Re: SSD 7101 - Mixed Use Hotel, Residential, Club and Retail Development, Goldfields House, Fairfax House and The Rugby Club Site

This letter comprises a submission on SSD 7101 which seeks Stage 1 concept approval for the following development of Goldfields House, Fairfax House and The Rugby Club Site:

A mixed residential building (max. 185m / RL191) comprising a slightly modified version of the approved Tower A; a hotel building (max. 110m / RL112.5) incorporating a new Registered Club; and a five level basement car park across the site.

drawing title
MASSING ENVELOPE LEVEL 4

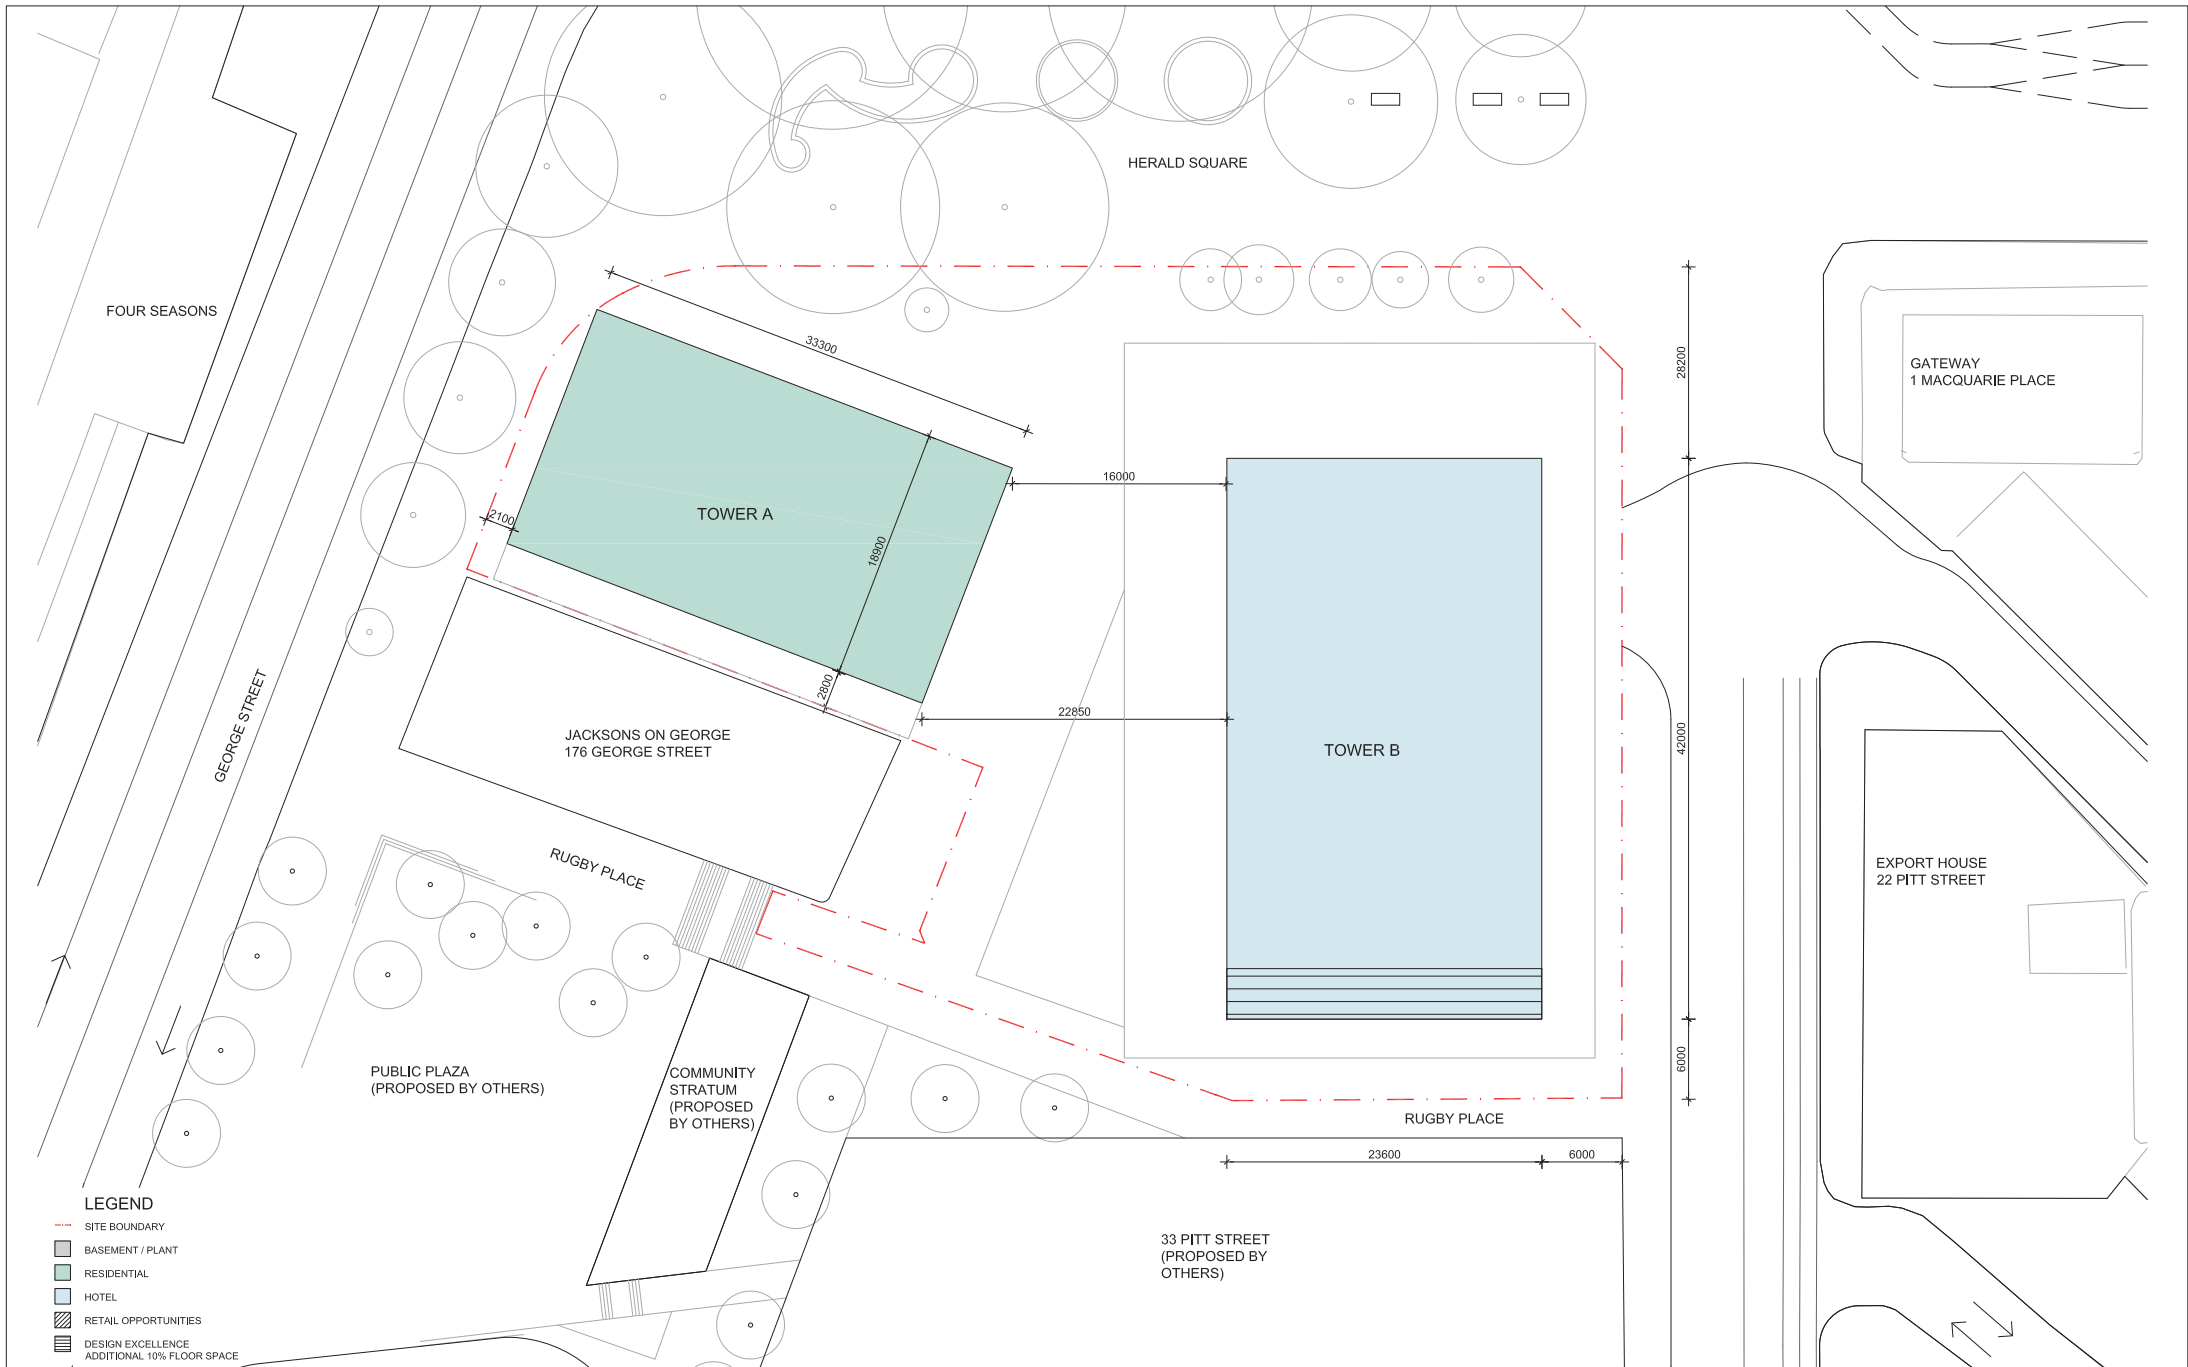
The City of Sydney has consistently deferred approval of the 10% bonus FSR until completion of the competitive design process and approval of the Stage 2 DA to ensure that developments fulfil their design excellence obligations under SLEP 2012, cl. 6.21. Contrary to this practice, the applicant is seeking consent for a building envelope that includes a 10% design excellence FSR bonus across the entire site. The SSD DA plans should be amended to remove the bonus FSR volume.
